Hornton Parish Council

Response to planning application 21/00517/F

Wroxton Motocross Track

6 April 2021

PRoW: 339/18/10 footpath

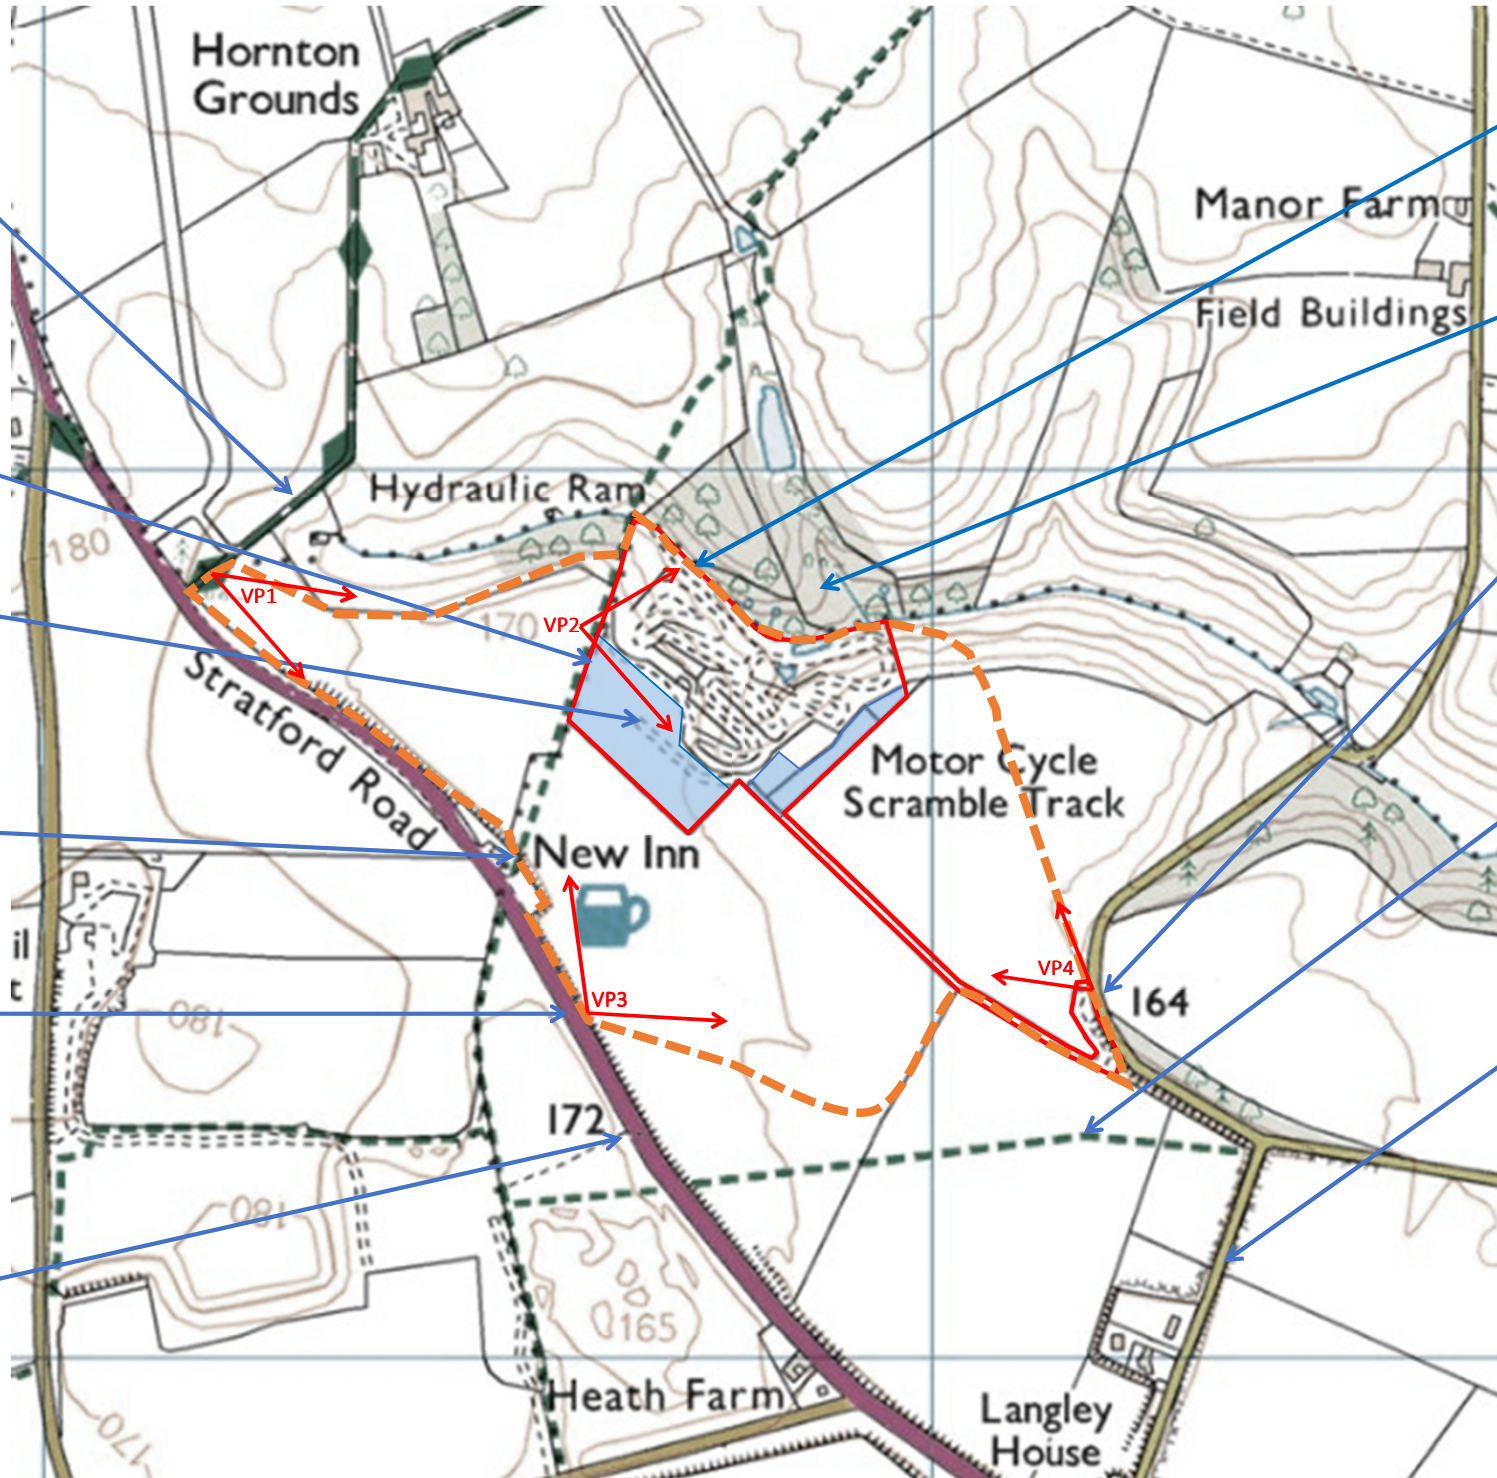
8. Pedestrian and Vehicle Access, Roads and Rights of Way. Point 4: Are there any new public rights of way to be provided within or adjacent to the site? The applicant has answered No. This is disingenuous. Because the same landowner has, just months ago (August 2020), agreed a change to part of the footpath route running on her land with OCC. The new route will be along the circuit access track and run alongside the site to join the existing footpath as shown in the map below:

However, there is also unobscured visibility from a Public Footpath directly along the boundary, running up the bank, right next to the starting line. As of summer 2020, there is also a Oxfordshire County Council diversion planned, to which Mrs Kerwood consented, to this Public Footpath that will take it directly along the so-called camping site boundary. This will also run along the length of the existing vehicle access: so

the path will run around two sides of the site (currently it skirts one side only) and walkers will be right next to the long dirt avenue of access traffic. (See map below)
